**From:** Al-Najjar, Marwa G.  
**Sent:** Friday, March 31, 2017 2:21 PM  
**To:** 'David Soule'  
**Cc:** Biazar, Shahab  
**Subject:** RE: Mesa Cold Storage Repave Project (file--h13d108)

ENGINEER'S SEAL	MESA COLD STORAGE	DRAWN BY WCWJ
	GRADING AND DRAINAGE PLAN	DATE 2-07-17
		21707-LAYOUT-2-07-17
DAVID SOULE P.E. #14522		1606 CENTRAL AVENUE SE SUITE 201 ALBUQUERQUE, NM 87106 (505) 872-0999
		JOB # 21707

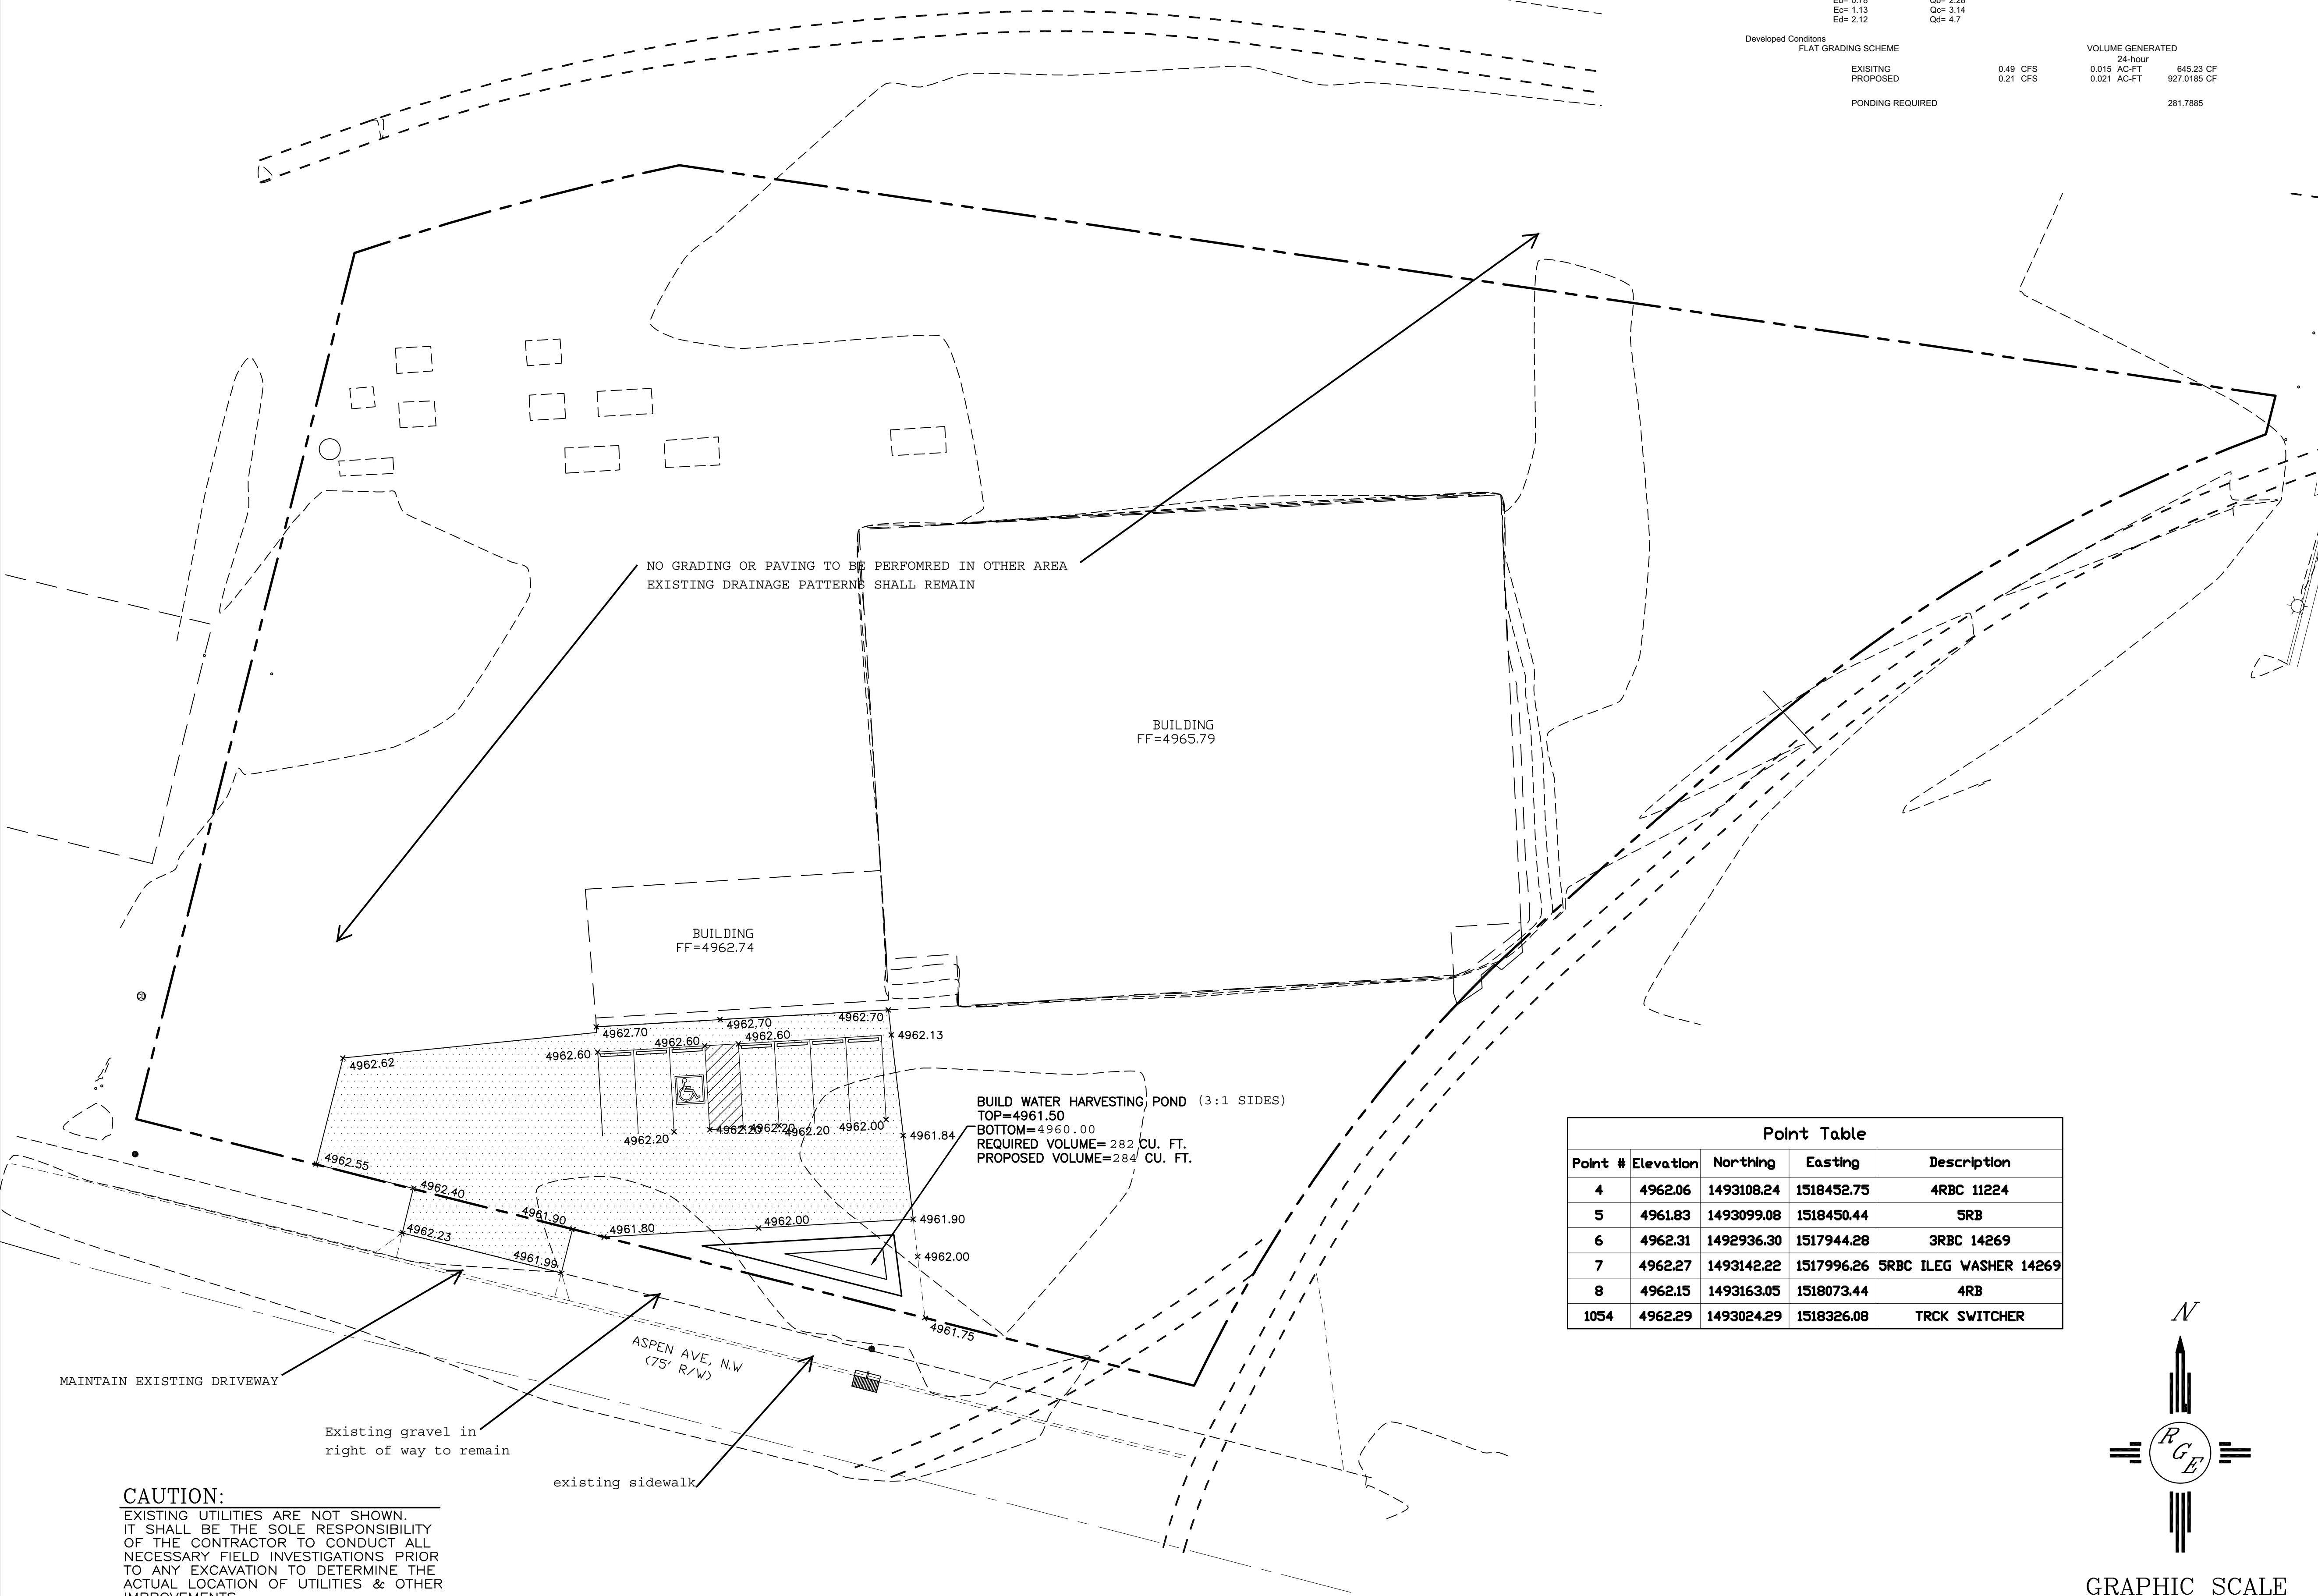
We have already reviewed it and we still need you to provide the following:

- Flow line elevations along the south side of the site.
- It appears there is a low spot elevation on the east side of the parking lot it will cause water harvesting.
- The sidewalk culvert invert shouldn't be the same as top of pond elevation.
